Sheringham Shoal and Dudgeon Offshore Wind Farm Extension Projects

Cover Letter - Non-Material Change

March 2023

Non-Material Change Application

Title:
Figure 19.7 PRoW, Paths and Cycle Routes
Sheet 1 of 6

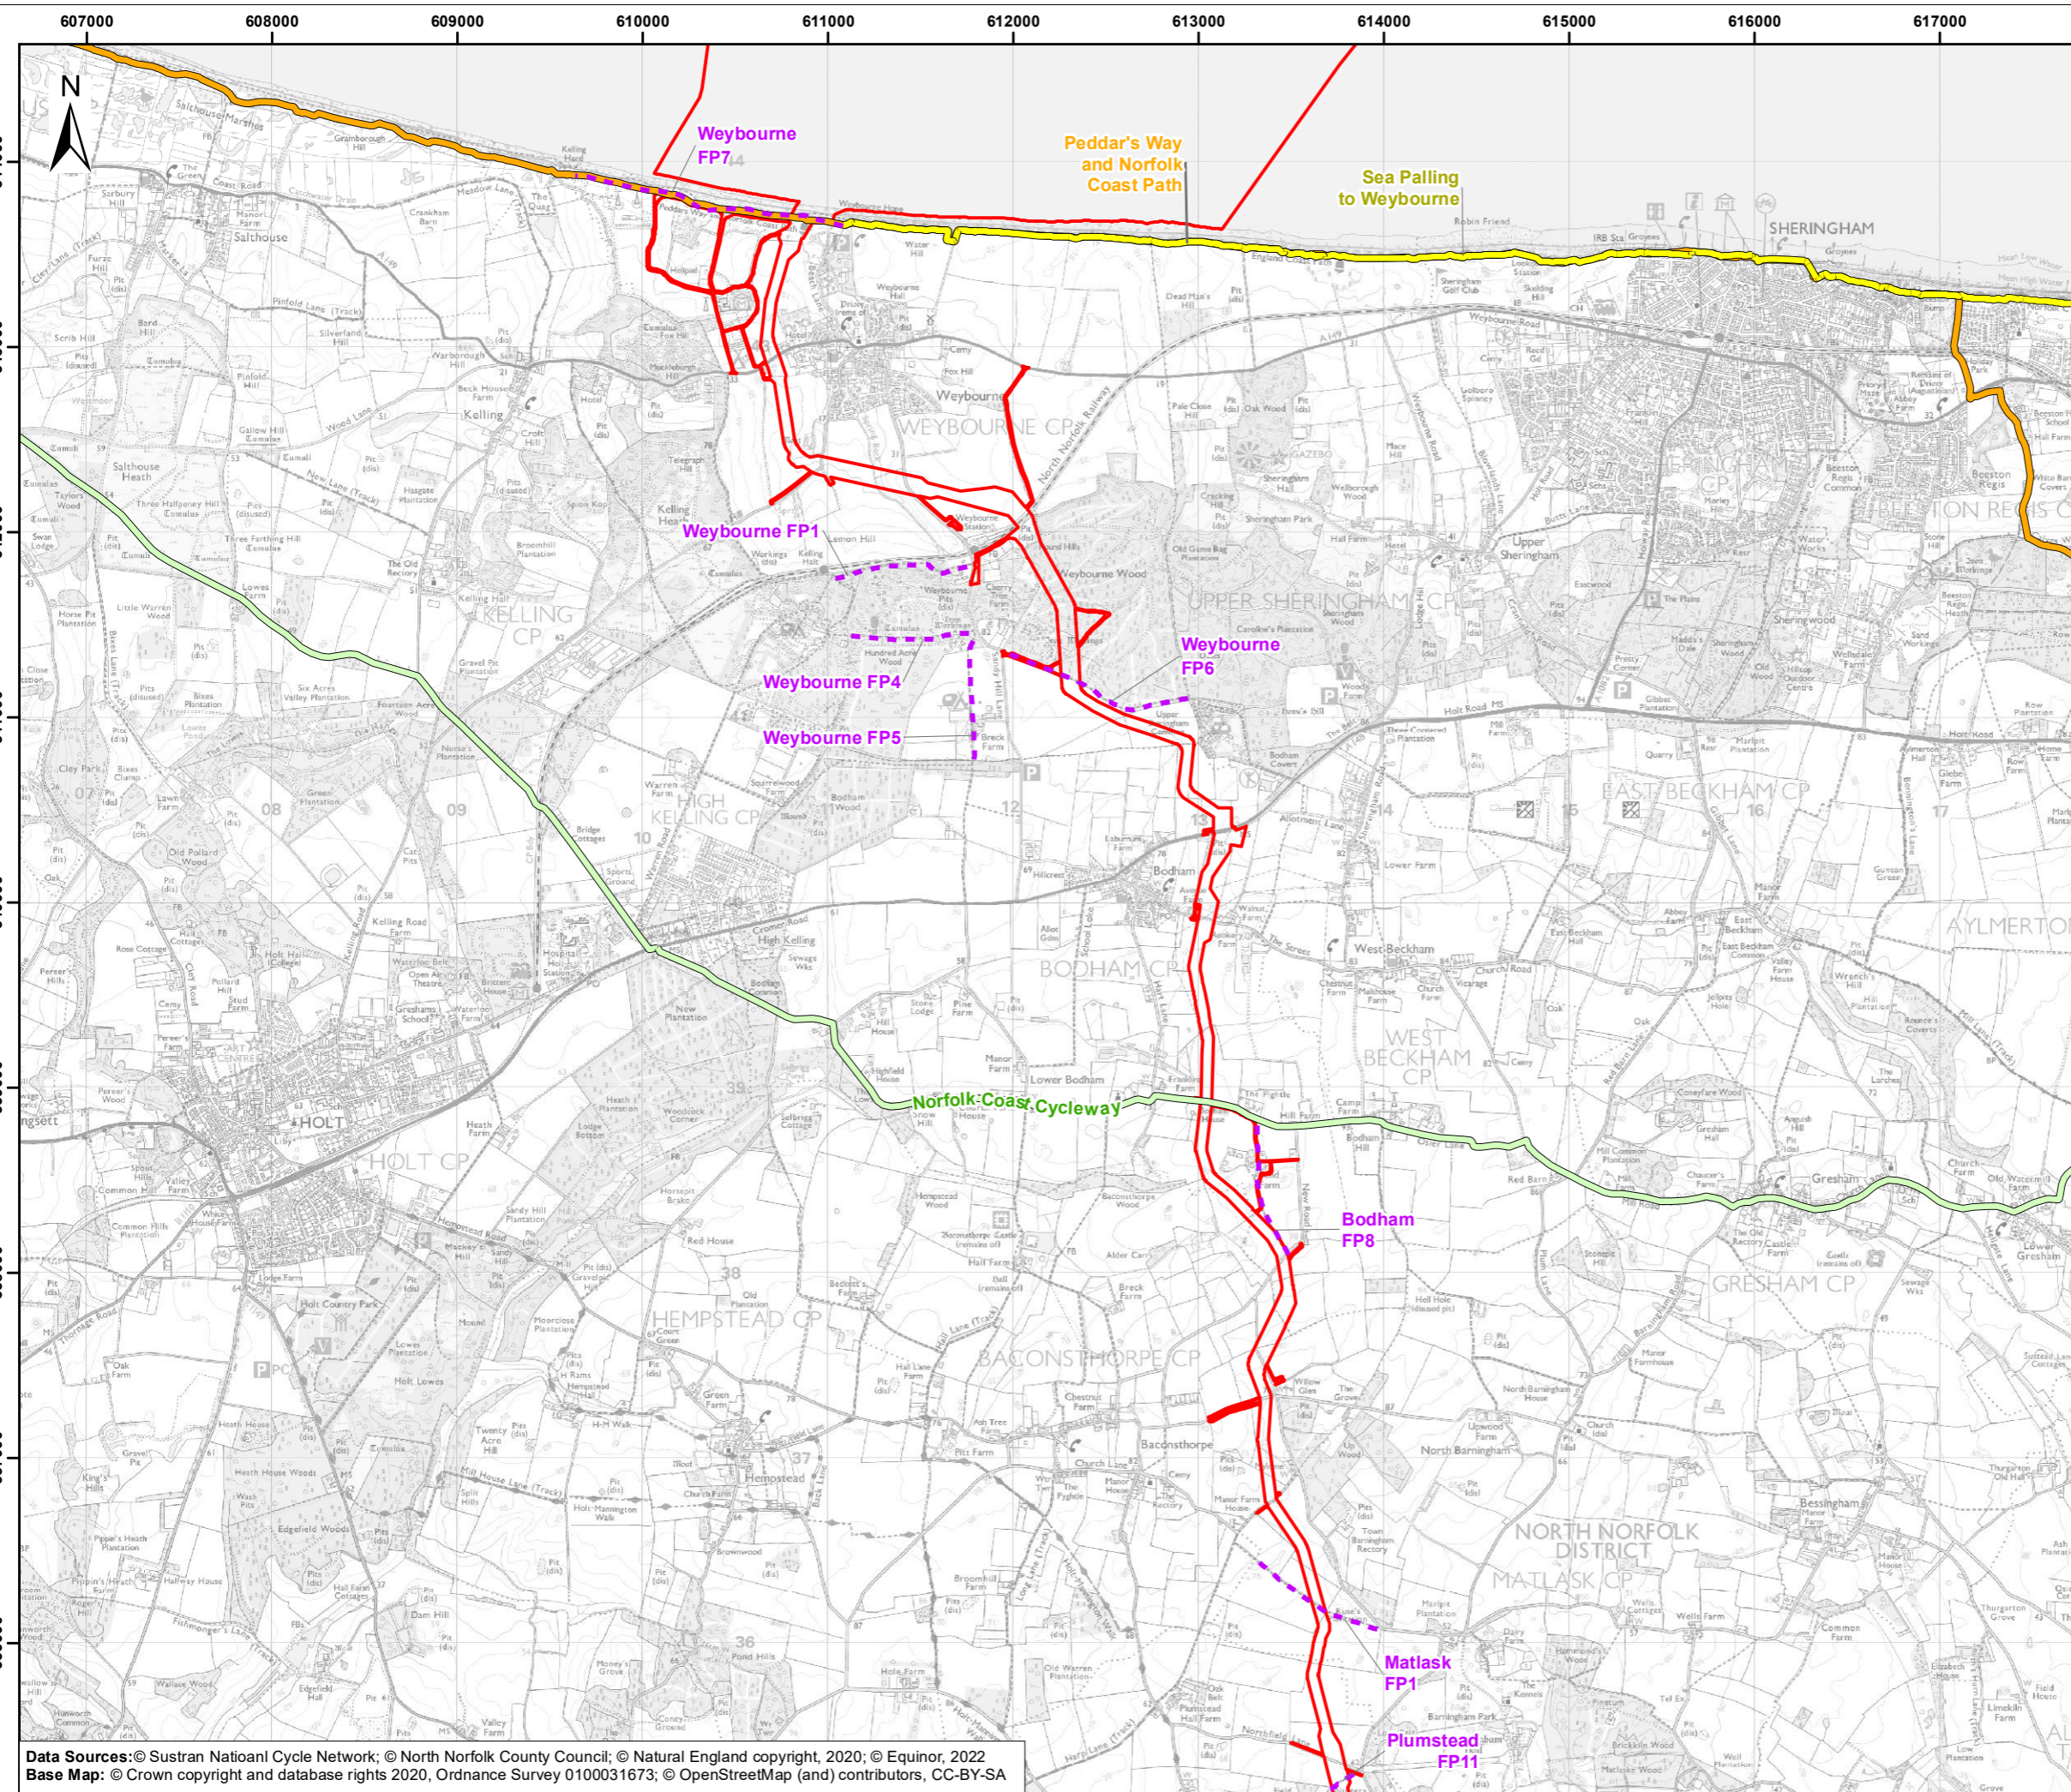
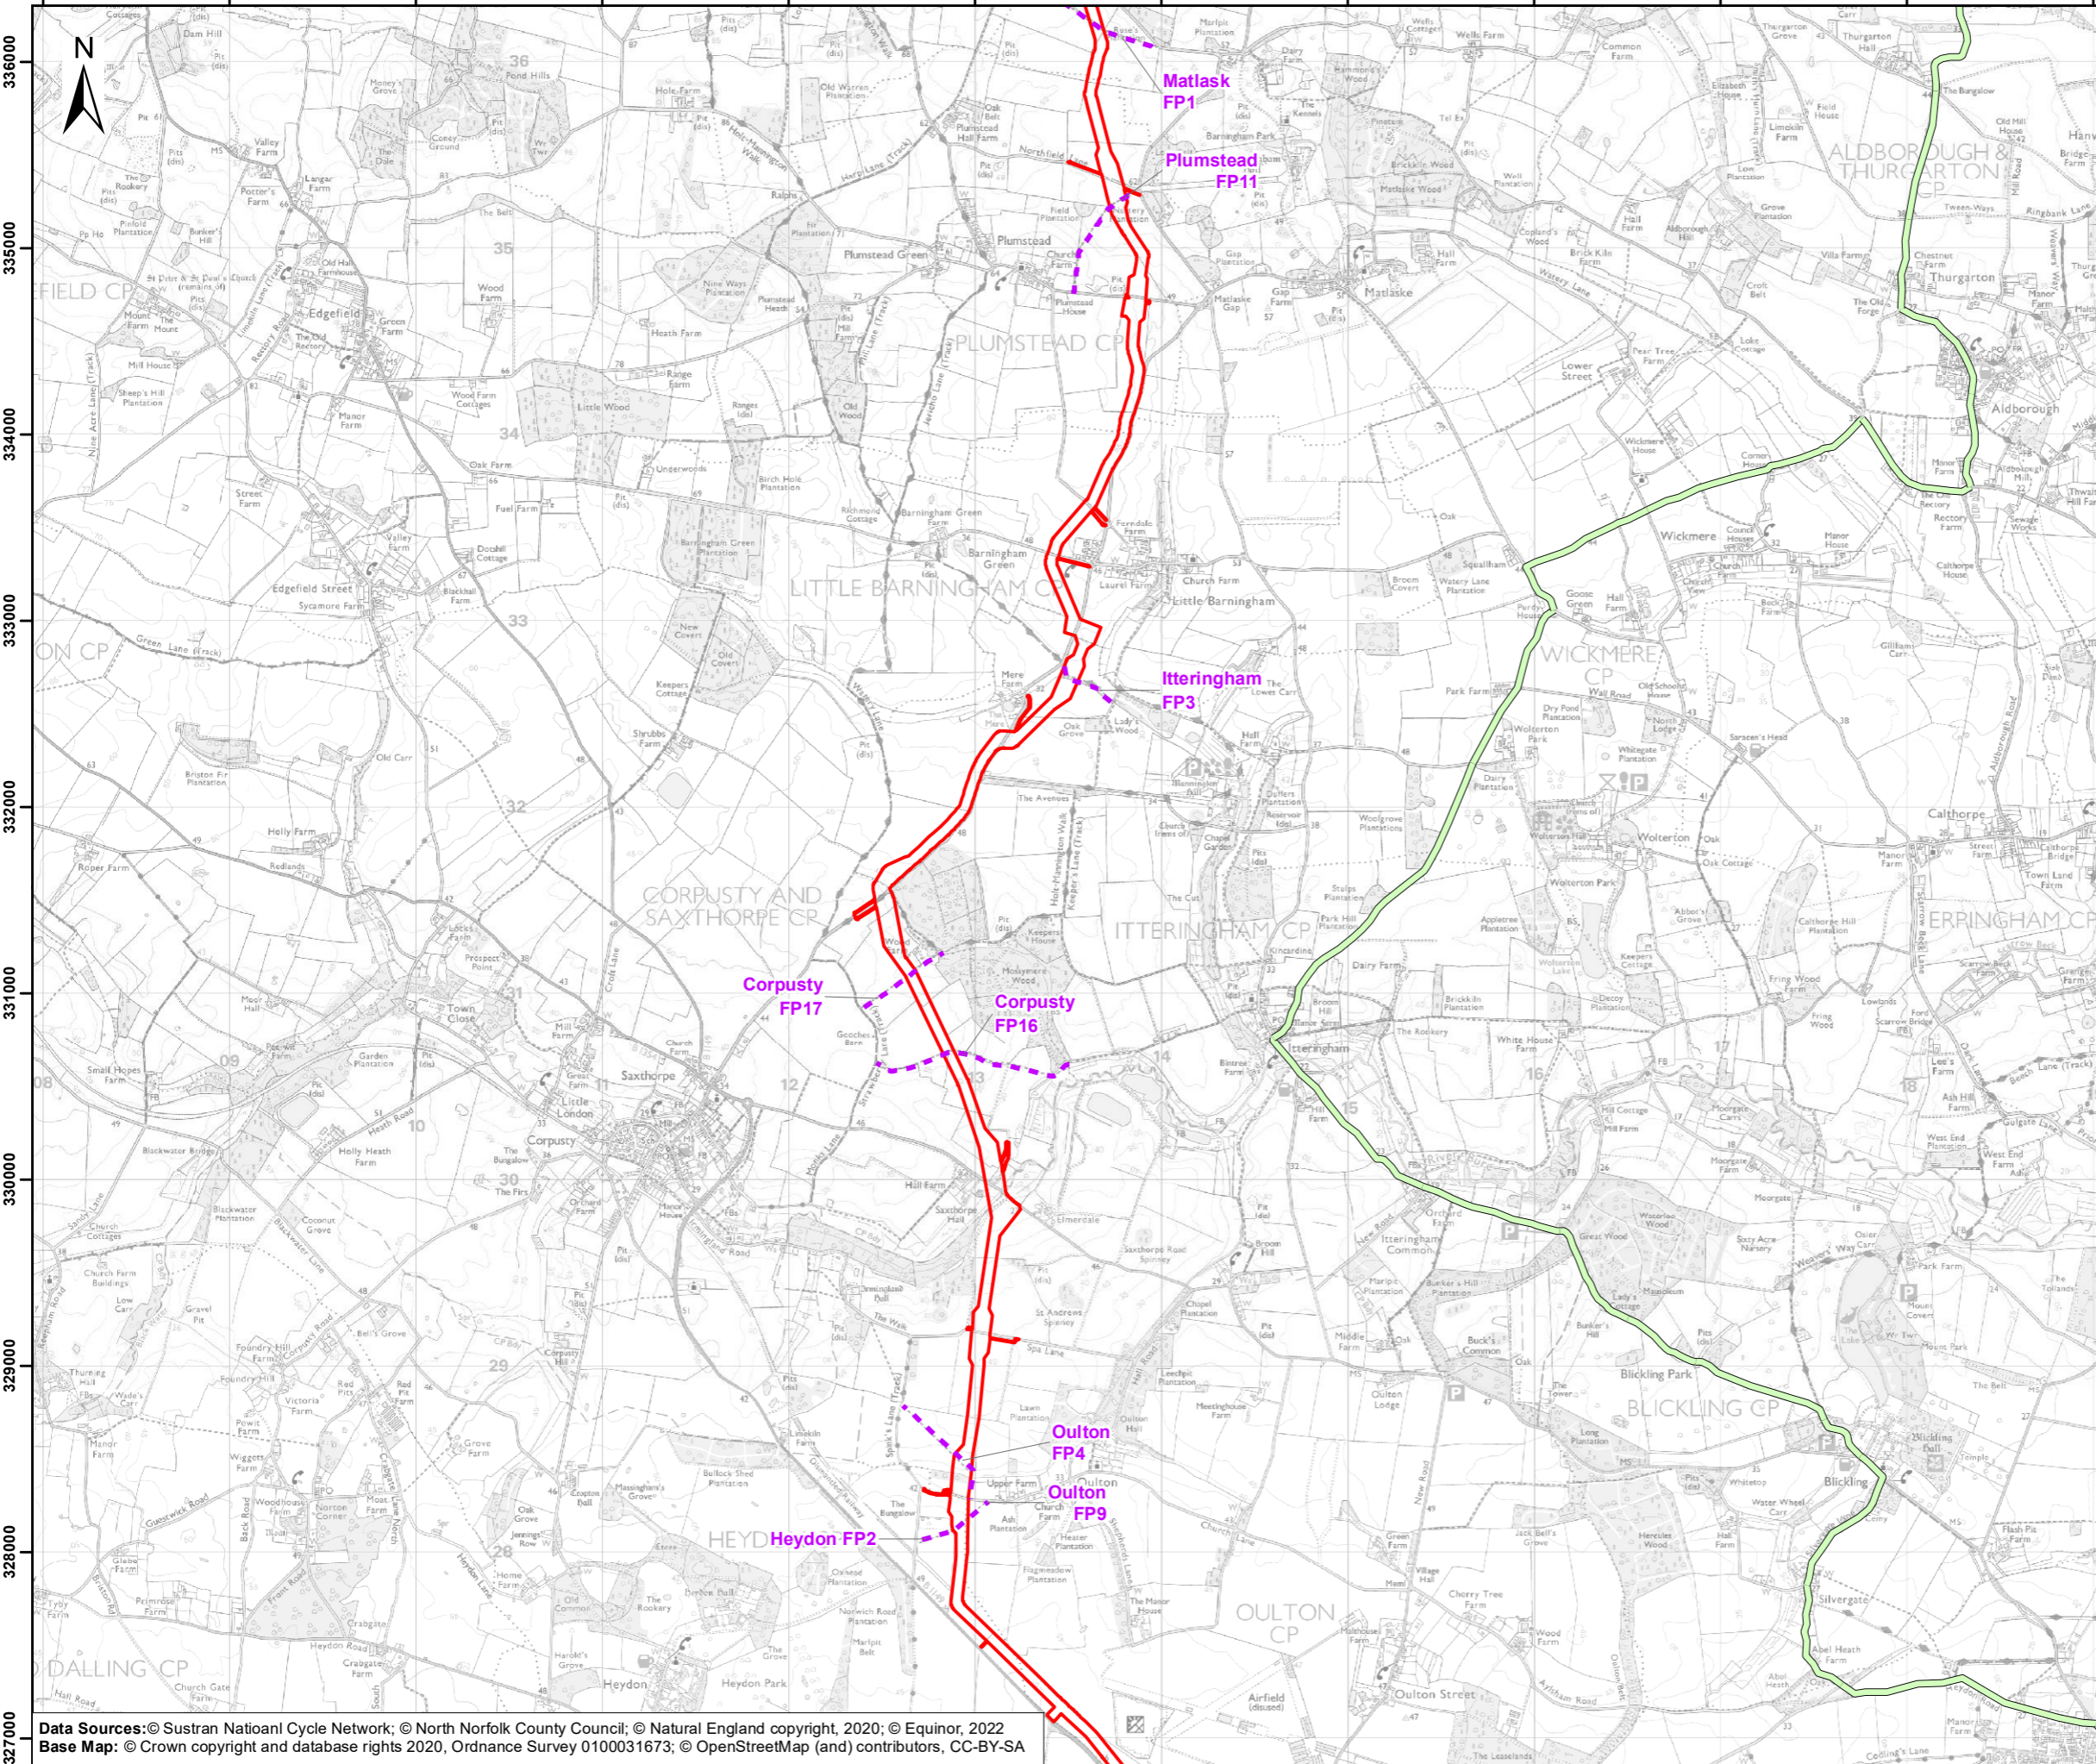
As a result of the changes to the Order Limits to remove the Anglian Water foul sewer connection, **ES Chapter 19 Land Use, Agriculture and Recreation (Revision B)** [document reference 6.1.19] and Figure 19.7 PRoW, Paths and Cycle Routes of **ES Chapter 19 Figures - Land Use, Agriculture and Recreation (Revision B)** [document reference 6.2.19] have been updated to reflect the Public Rights of Way (PRoW) which are located within the Order Limits. The number of PRoW which are intersected by the Order Limits and presented in Table 19-14 of the chapter has reduced. This reduction does not result in a change to the overall assessment and conclusion of likely significant effects presented in the chapter.
